Our ref: DOC21/350760-14

Advice on EIS - Budawang School for Special Purposes (SSD-8845345)

Thank you for your referral dated 4 May 2021 inviting comments from Heritage NSW on the exhibited Environmental Impact Statement (EIS) for the above State Significant Development (SSD). We note that the development application is for demolition of existing infrastructure (including a preschool and school building), earth works and construction of five purpose-built buildings (and associated infrastructure including carpark, landscaping, fencing and signage), for a new school for special purposes in Milton, NSW (Budawang School).

**1 BLOCK C PLAN**  
1:100

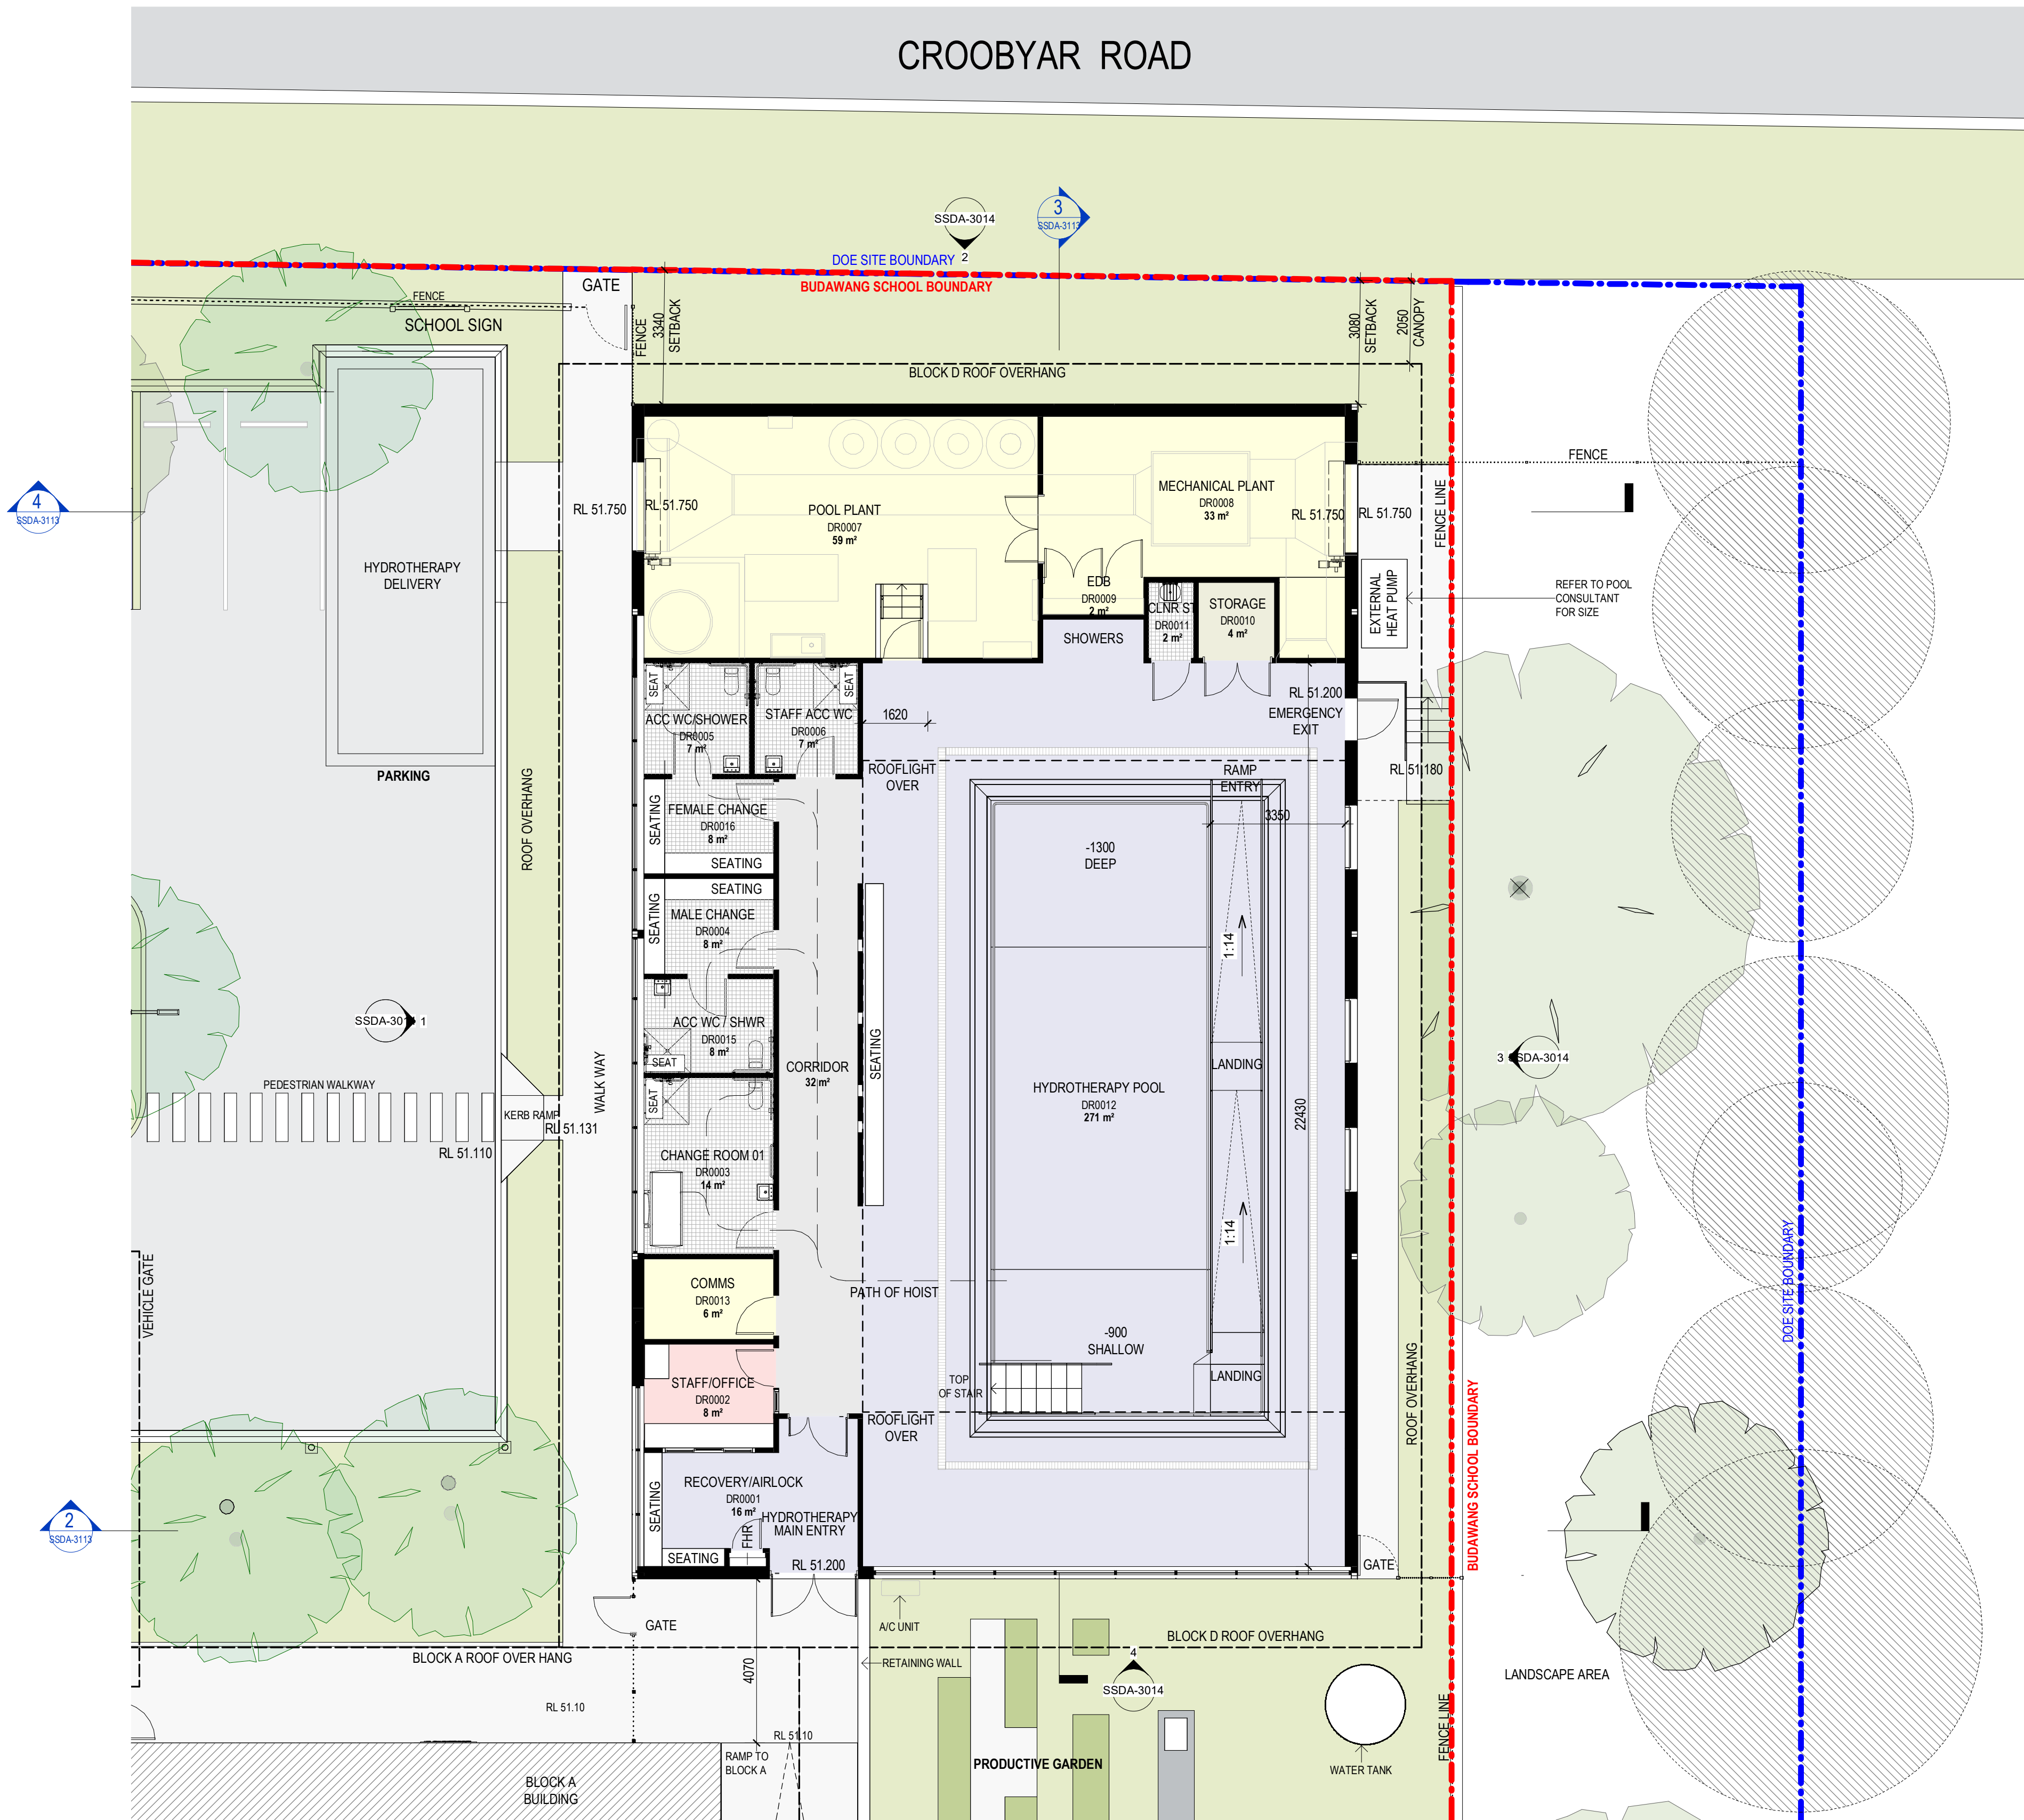
This artefact scatter, and associated PAD will be directly harmed during earthworks and construction of building: block C. The ACHAR has not demonstrated attempts to avoid impact upon cultural heritage values, identify conservation outcomes, or propose measures to mitigate impacts. The EIS and the ACHAR found that 'the proposal will result in minor but acceptable impacts on Aboriginal cultural heritage'.

The proposed development will directly harm Aboriginal cultural heritage. The artefact scatter, with associated PAD, will be directly impacted during construction of the school. In considering the EIS, ACHAR and Consultation Report, their findings and recommendations, and harm to the Aboriginal heritage site, Heritage NSW recommends the following:

- An Aboriginal Site Monitor should be present during works that impact subsurface within the location of the artefact scatter, and associated PAD. This will require the boundaries of the site, and associated PAD to be defined and mapped prior to works commencing.
